SSD 7382 UTS Central, Broadway Precinct

Detailed Response to Submissions – July 2016

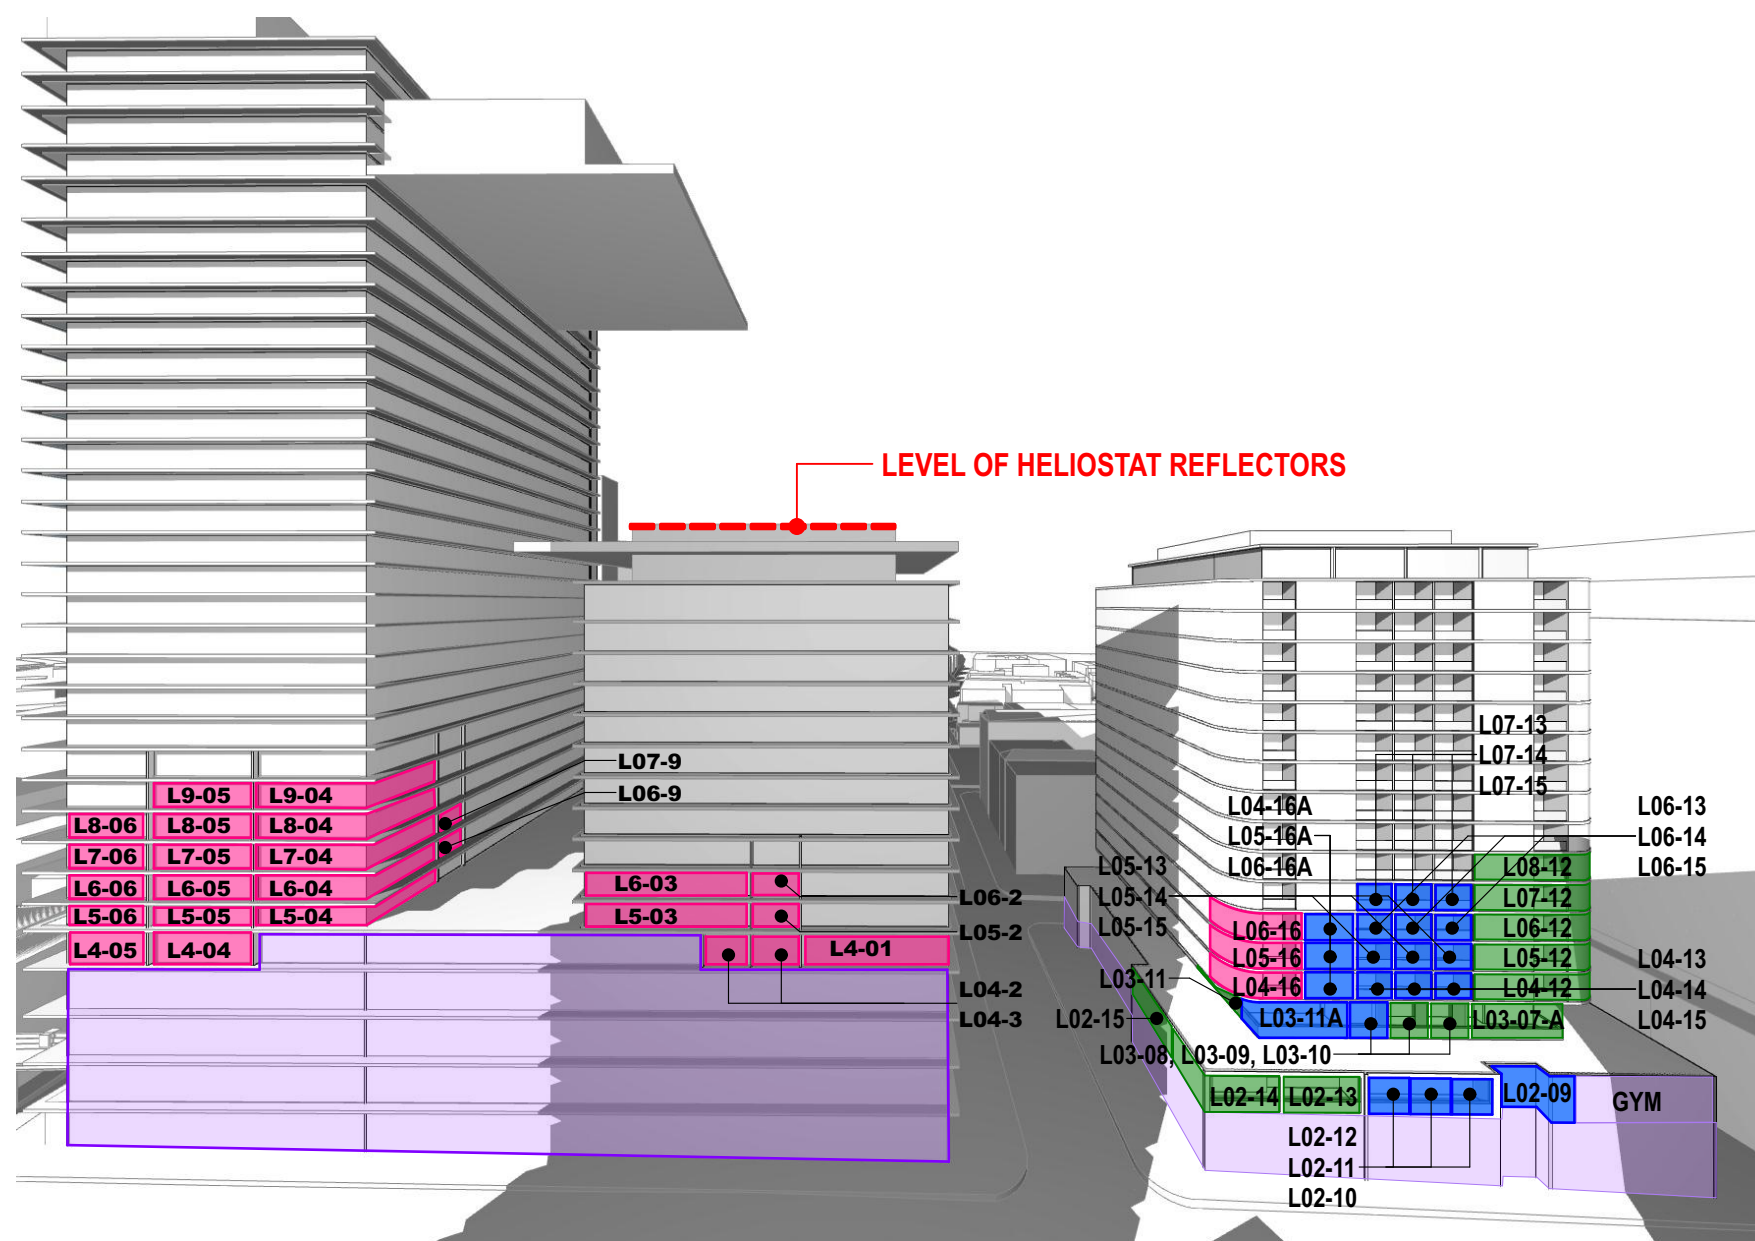
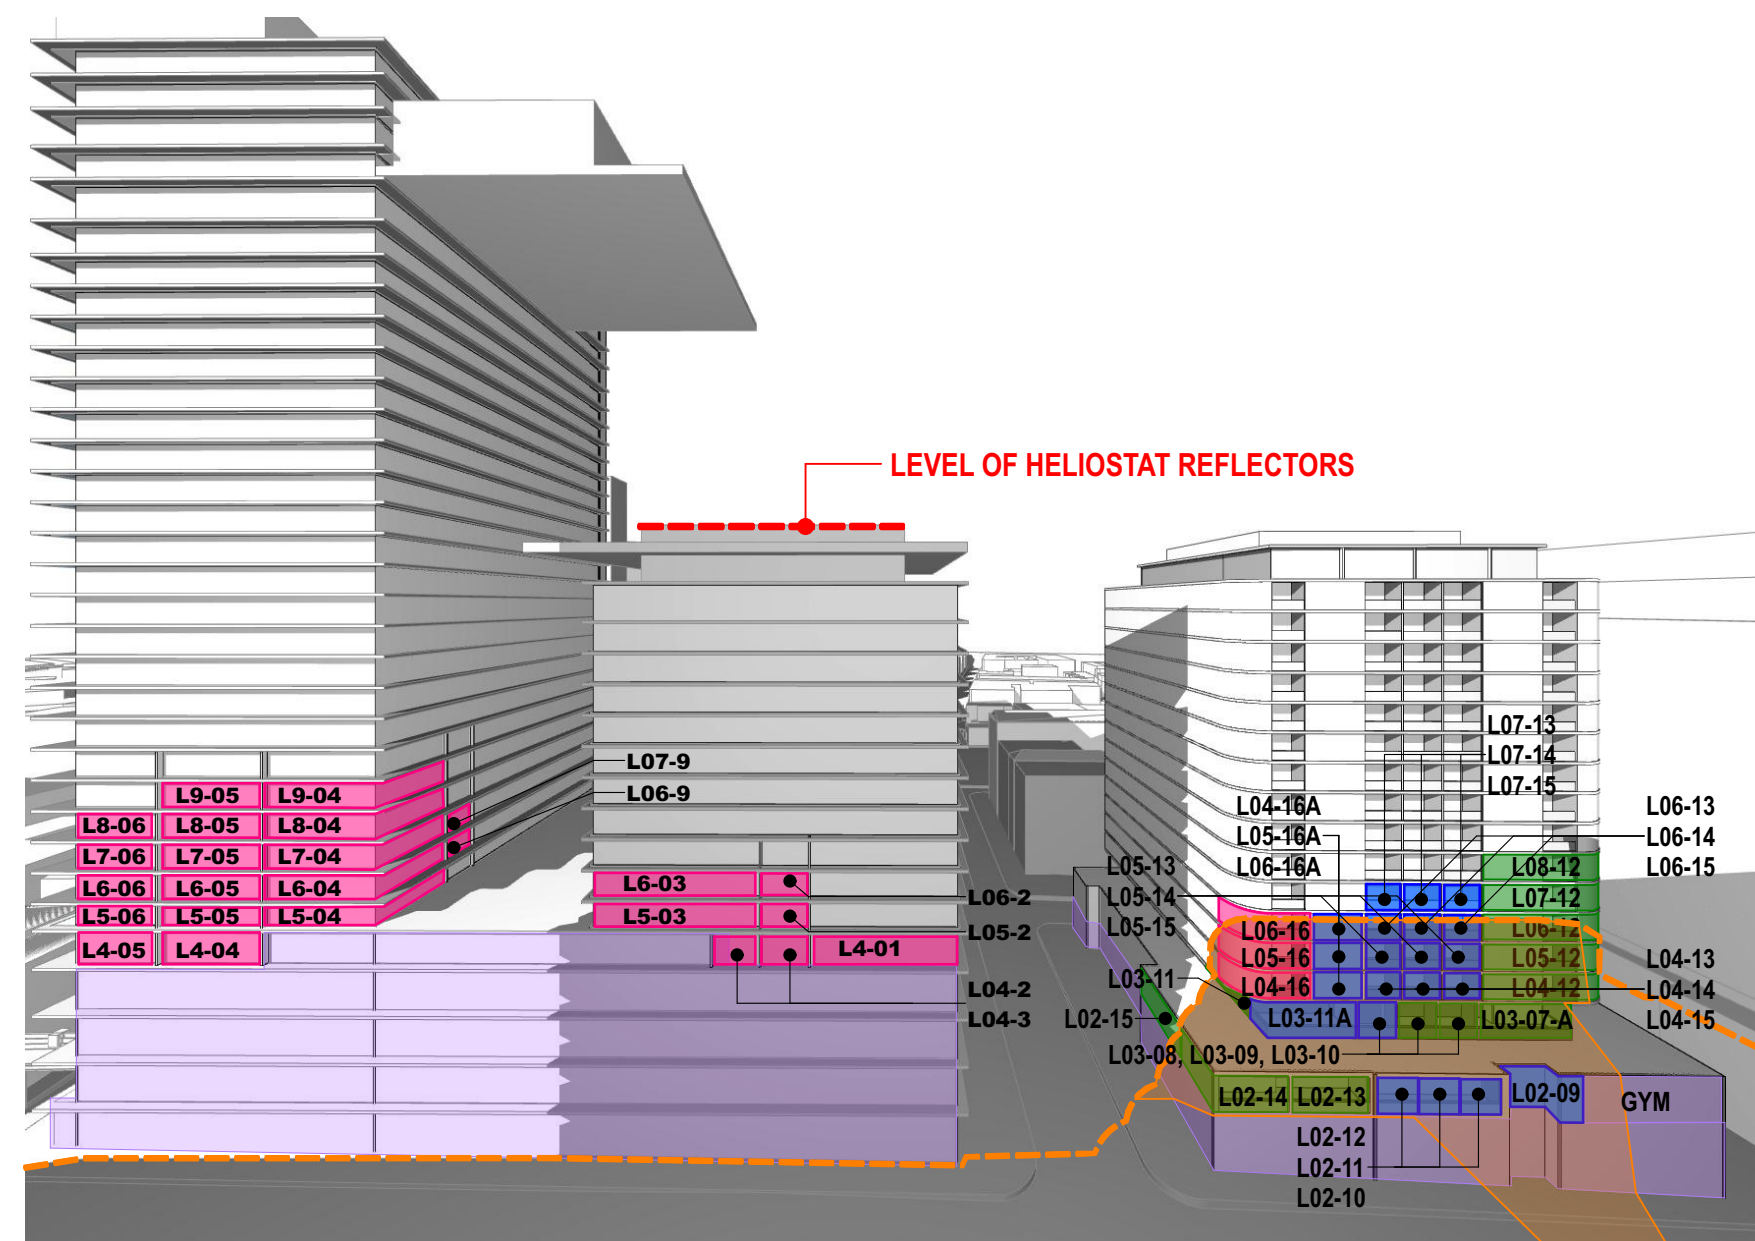
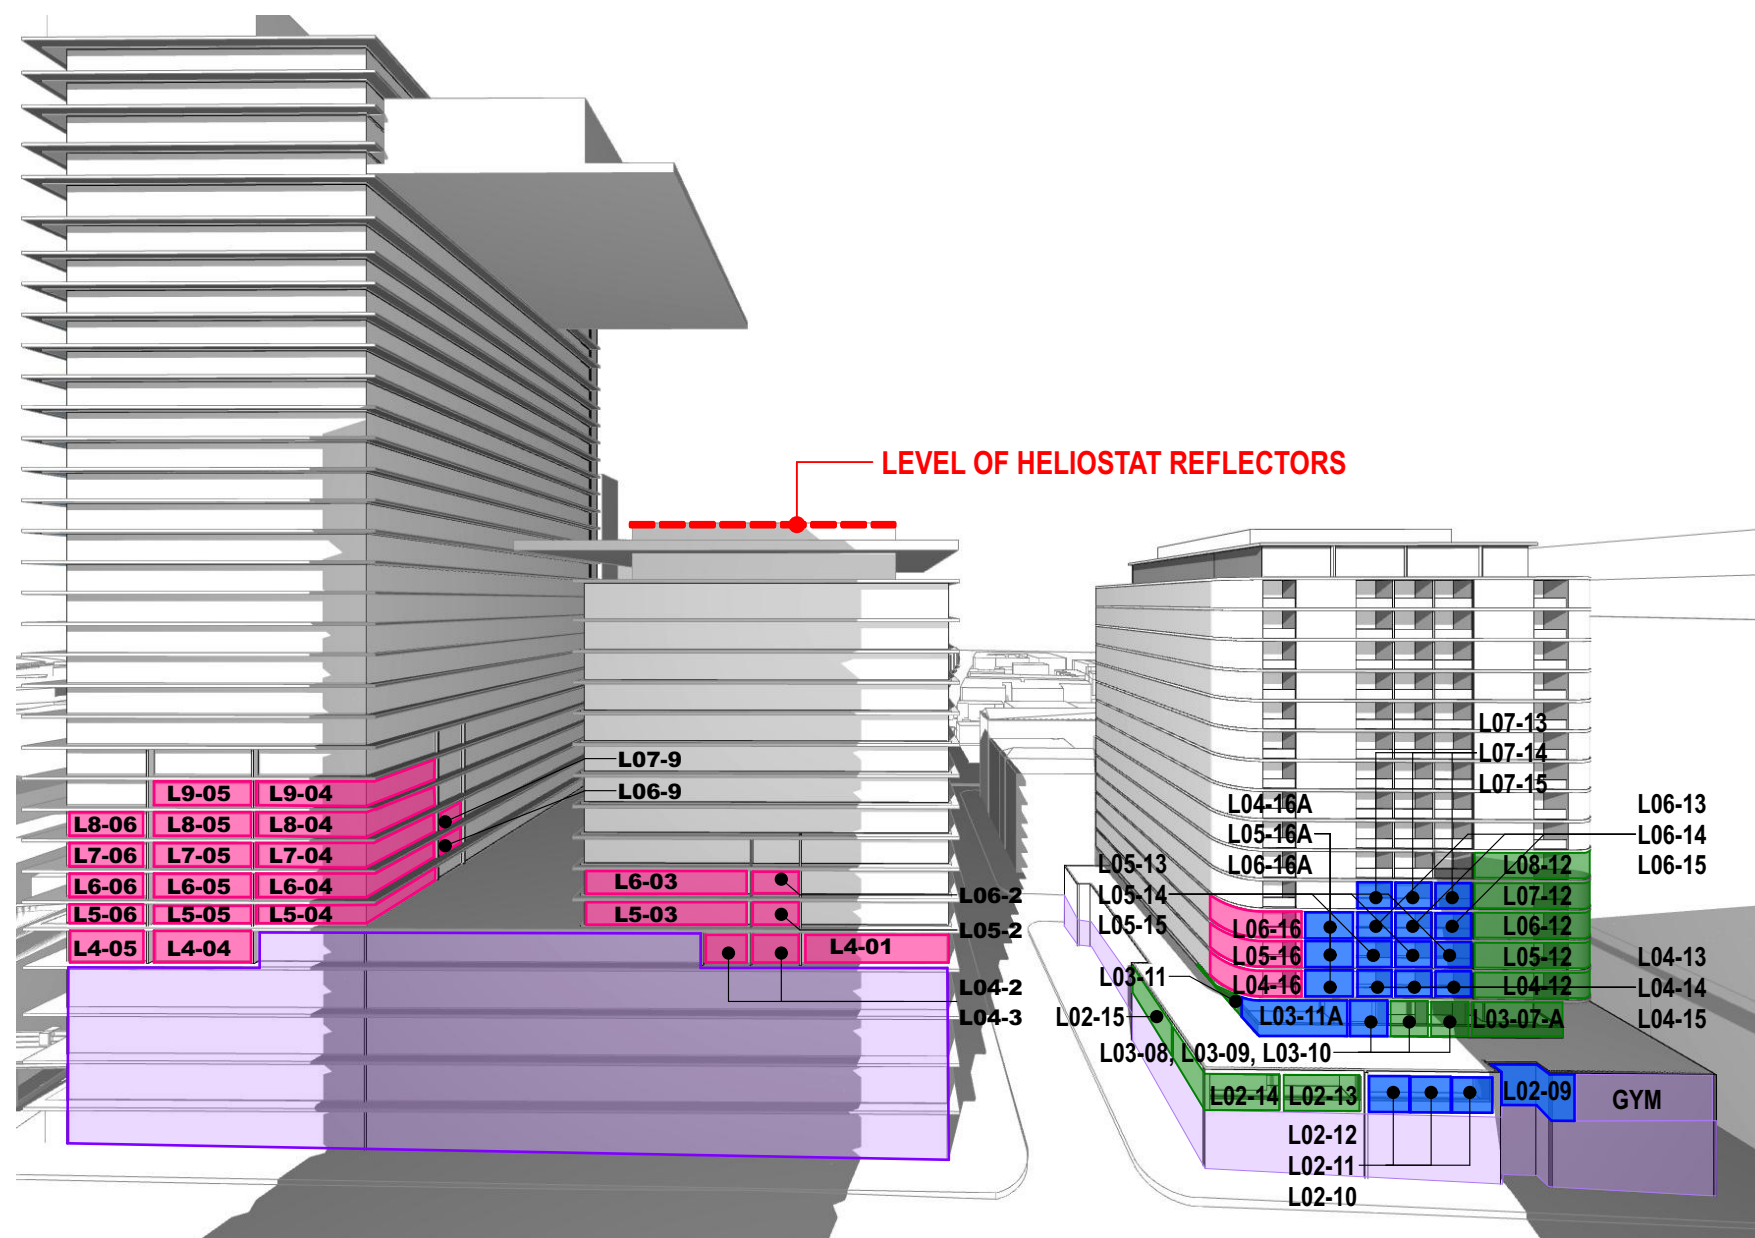
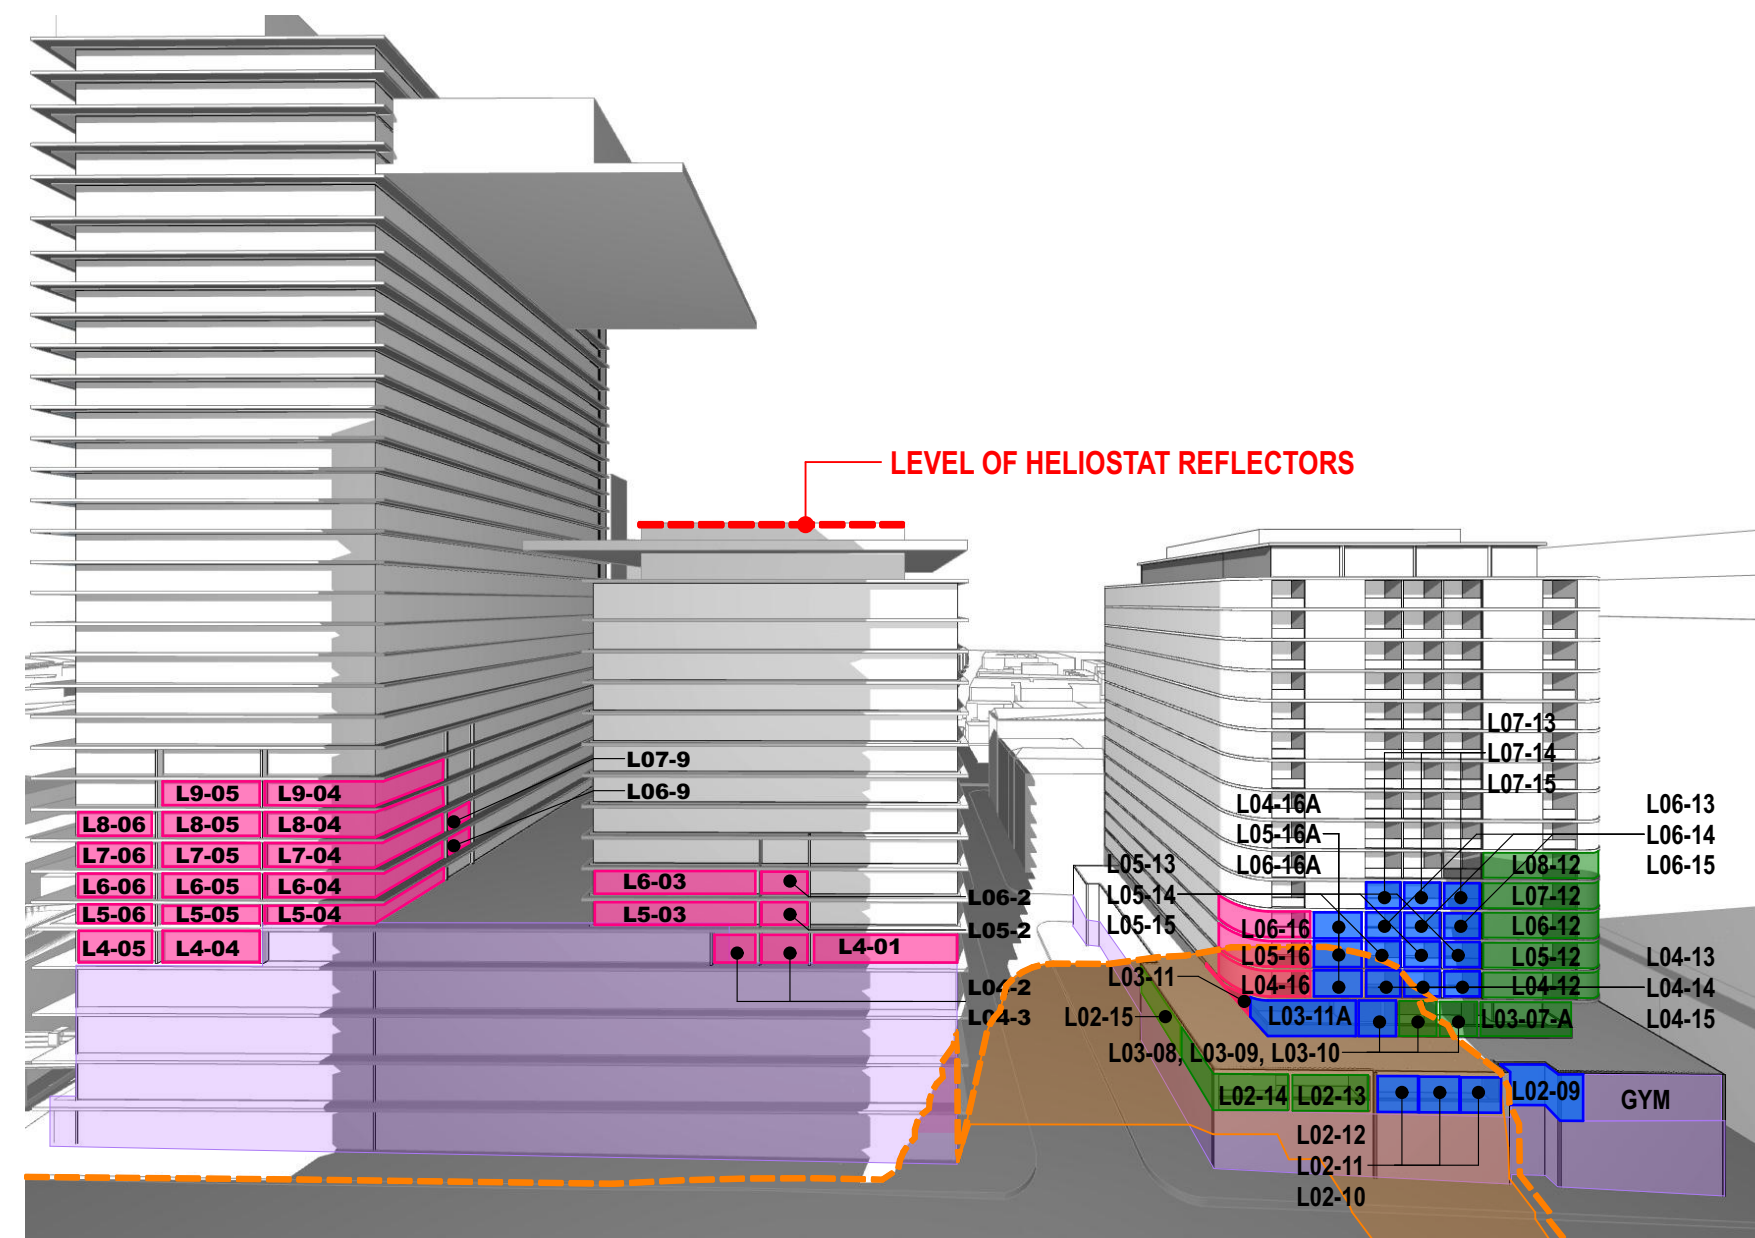
<p>Environmental and Residential Amenity</p> <p>5. The Department is concerned with the overshadowing impacts from the proposed building on the residential properties within Central Park and a further quantitate analysis of solar access to be retained and lost for all dwelling impacts by the proposal must be provided, including additional analysis of whether the proposal would impact on any heliostat solar collectors for building within Central Park.</p>	<ul style="list-style-type: none"> - FJMT and JBA have completed a detailed analysis on the overshadowing impact from the proposed building on the residential properties within Central Park as outlined within the main report. - The holistic assessment of the various amenity considerations for Block 1 demonstrates that notwithstanding the lower achievement of direct sunlight access, Block 1 will deliver a high level of residential amenity. - The proposed development is the same height as the lower tower of No. 1 Central Park and does not impact on the roof level of the lower tower where the reflectors are located or the roof level of the higher tower where the heliostat is located.

Solar & Daylight Access <p>In order to demonstrate that the proposed development is able to comply with Objective 3B-2 of the Apartment Design Guide and Section 4.2.3.1 of the Sydney Development Control Plan 2012, a solar analysis should be provided of the surrounding buildings and rooftop on which the heliostat solar collectors are located. A daylight report and LUX level map of affected apartments should also be submitted.</p>		<ul style="list-style-type: none"> - Detailed elevational shadow diagrams for Central Park (One Central Park and Block 1) have been prepared by FJMT (Attachment B) for June 21 (7.30am to 3pm) illustrating: <ul style="list-style-type: none"> - Shadows Cast by the modified Concept Plan (MOD 5 envelope) - Shadows cast by UTS Central SSDA. - Further, the existing building shadows cast over Central Park have been previously prepared and are also submitted with this report. - The proposal has been reviewed against the following: <ul style="list-style-type: none"> - <i>Objective 3B-2 of the Apartment Design Guide.</i> - <i>Section 4.2.3.1 of the Sydney Development Control Plan 2012.</i> - As outlined within the main report, the holistic assessment of the various amenity considerations for Block 1 demonstrates that notwithstanding the lower achievement of direct sunlight access, Block 1 will deliver a high level of residential amenity.
